**From:** DataSpace Consult [system@dataspaceconsult.co.uk]  
**Sent:** 18 June 2015 13:40  
**To:** Planning  
**Subject:** Comments Added: 31 Salisbury Square Hatfield AL9 5JD

Application ID: S6/2015/1034/MA - Mr M Peacock Application Owner: Welwyn & Hatfield Borough Council(Development Management Officer)

Description: Change of use from existing offices (B1) to six residential dwellings (C3), extension and conversion of existing loft space to one dwelling and erection of new block in existing car park to provide th Comment Added:

Site & Ground Floor Plan scale 1:100

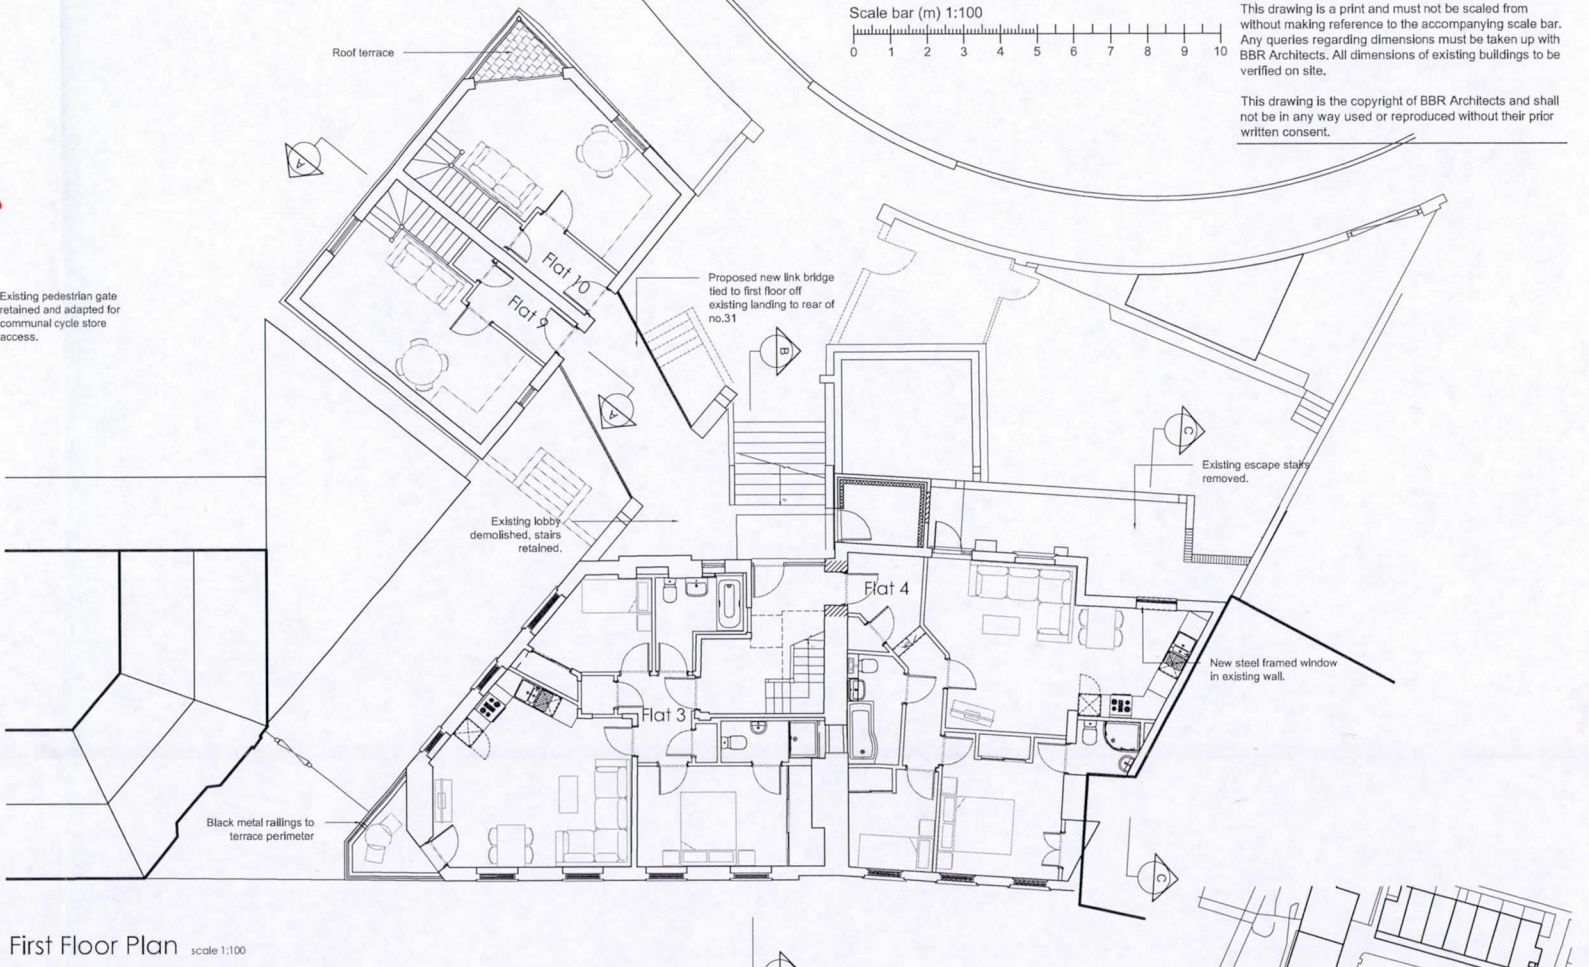
Comment: Hatfield Town Council express concern that the application fails to provide any car parking spaces in the proposals. In fact the application loses the 5 car parking spaces that are currently on the site.

Old Hatfield is particularly short on car parking and a proposal to create dwellings without car parking spaces was not considered appropriate by the Town Council Planning Committee.
